Following a meeting with the applicants on the 27th June the RNLI are content in principle with the measures proposed by the applicant in responding to the concerns previously outlined. A copy of the meeting notes is attached as an agreed summary of that meeting.

## **Notes of meeting between Morgan & Morecambe Transmission Assets Project and the RNLI – 27 June 2025**

Figure 4 Indicative Beach Working Areas for Cable Installation Works

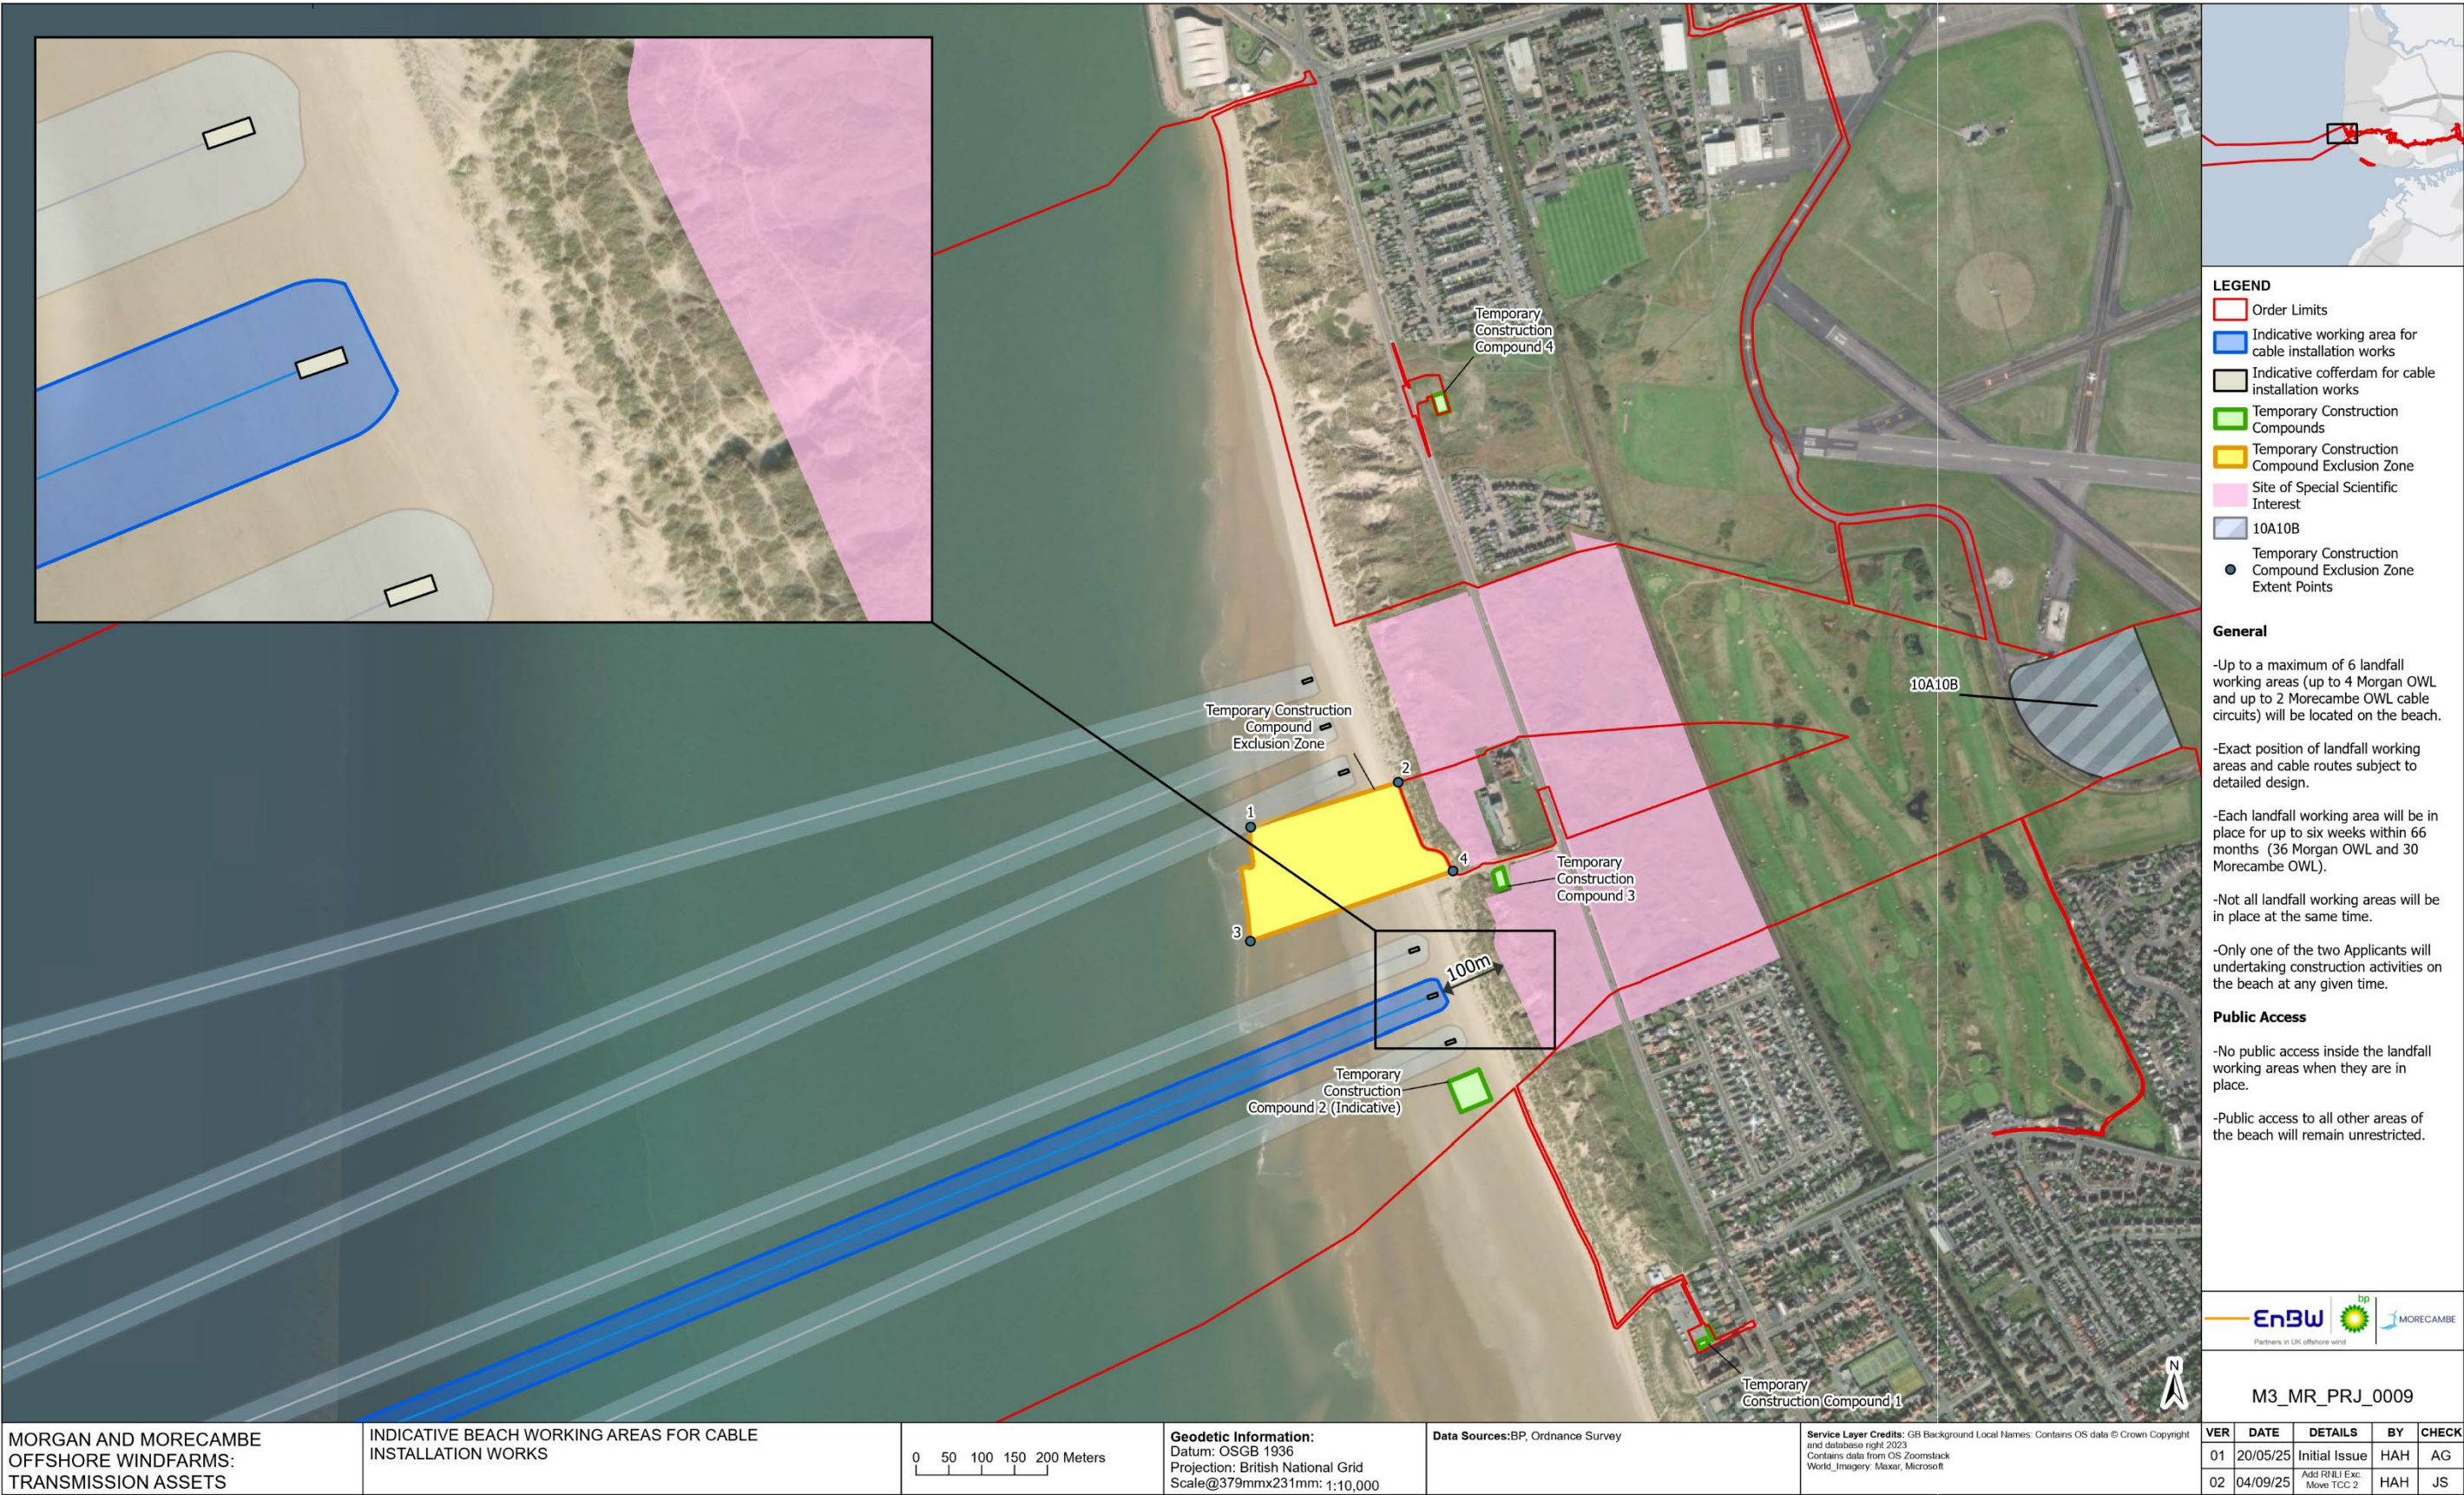
The applicant is to provide further information in due course concerning the exact positions of the cable coffer dams, to ensure that adequate spacing has been provided to enable recovery of the lifeboat between the sets of coffer dam inlets, and that sufficient space is retained to enable recovery east of the coffer dams and between them and the dunes.

Adequate and unimpeded access space for lifeboat recovery should be provided at all times during and after the construction works.

Making reference to Annex 5.3 to the Applicants response to Hearing Action Points: ISH1 13, 14, 16, 17 (REP1-040) (which sets out additional information regarding the works proposed at the Lytham St. Annes Beach to facilitate the landfall of the offshore export cables) and Figure 3 in REP1-040 in particular, the Applicants explained that at all times, transport of the lifeboat would be possible landward of the cofferdams (between the cofferdams and the sand dunes). Additionally, passage seaward of the cofferdams would also be possible except during the cable pull-in and installation process (up to 6-weeks per cable). The RNLI explained that launching the Lytham St. Anne lifeboat was undertaken to the south of the proposed landfall works area and therefore, was not a concern. However, the RNLI do recover the lifeboat in the landfall works area. The RNLI explained that they usually land the lifeboat on the beach directly in front of the Thursby/Century care home. The Applicants explained that as the export cables will be routed within the landfall works area to the north or south of the care home, there will be a natural gap on the beach in front of the care home where cables would not be routed (as illustrated by the indicative location of cofferdams in Figure 3 of REP1-040) and the RNLI lifeboat recovery location should not be affected, to which RNLI agreed.

The Applicants did point out that recovery operations during cable pull-in activities of the closest export cables to the beach area in front of the care home could impact on the lifeboat recovery location (just for the duration of the works for that cable), but it was agreed that it would likely be by tens of metres, which the RNLI confirmed it could accommodate. Following beaching, it was agreed by the RNLI that the lifeboat could be

recovered by heading east up the beach towards the sand dunes and then heading south between the cofferdams and the sand dunes to the lifeboat station at Lytham St. Anne to the south of the landfall works area.

The RNLI asked whether the locations of the coffer dams could be shared with the RNLI once final positions confirmed. The Applicant agreed that positions could be supplied once the project design has been finalised post-consent.
